From:
Sent: 29 May 2024 15:21
To: contact_us@yorkshirewater.co.uk; planningconsultation@yorkshirewater.co.uk;
DCAdmin
Cc:
Subject: YW ref LNSS-V507807 - planning objection reference 2023-93082
Attachments: 1998 map showing highways across development land off Northgate
Cleckheaton.pdf; 2023-93082_+General_1012324 - sewers.PDF

Planning objection reference: 2023/93082

Discharge conditions relating to planning permission 2022/91730 - land adj 60 Northgate, Cleckheaton, BD19 3NB - demolition of former dairy/snooker centre/storage and erection of 9 light industrial units

Scott Lane, Cleckheaton, BD19 4JY – S116 Sewer Closure V326571

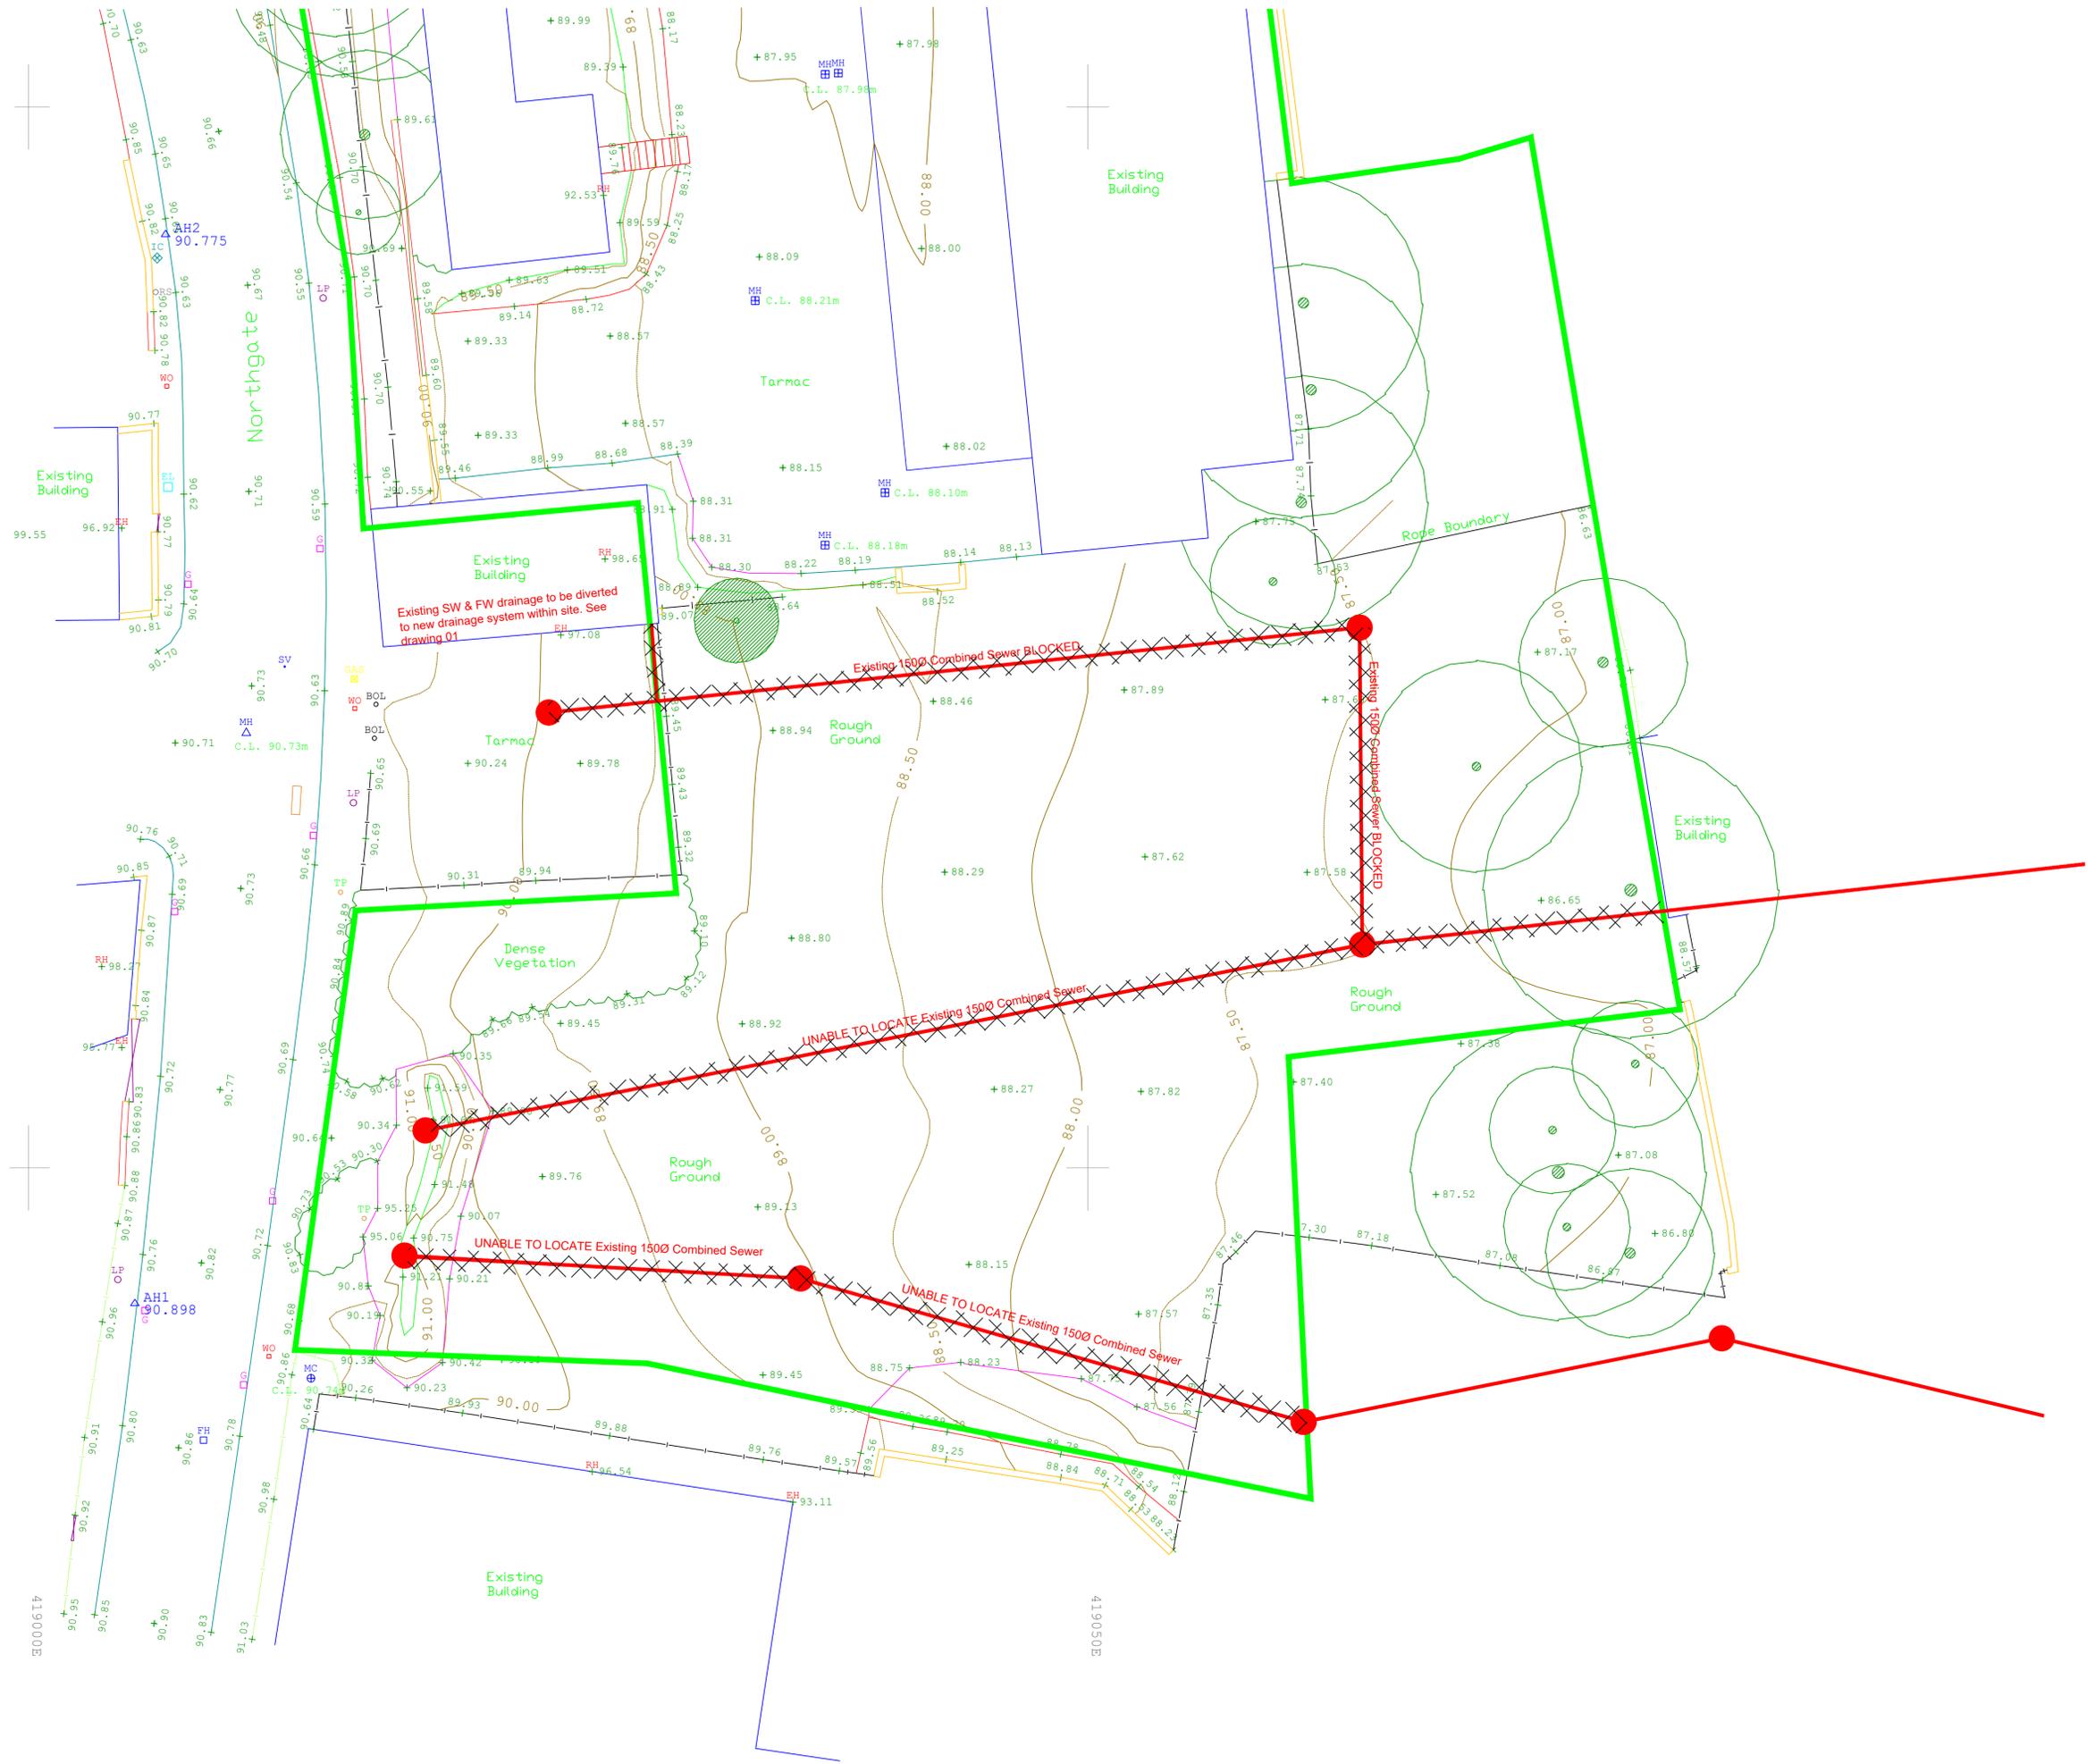
The map attached correlates with drawing number EWE/2514/03 attached (planning document General 1012324), submitted in connection with present planning application 2023/93082 which is concerned with the proposed development of light industrial units on the same site. This map both confirms and explains the existence of a public sewer running from the car park of my property

across the development land, for which reason it's reasonable to assume that my property is served by the public sewer for which section 116 approval to abandon was inappropriately given.

Taking account of all of the following evidence - the location of the visible excavated waste pipe at my property, the information provided by the map attached, the location of the sewer as shown on drawing EWE/2514/03, and the gradient involved at the site - it's not reasonable to assume that my property at 60 Northgate would drain upwards in the direction of Northgate and no evidence in support of that has been put forward, for which reason I maintain that closure should not have been approved.
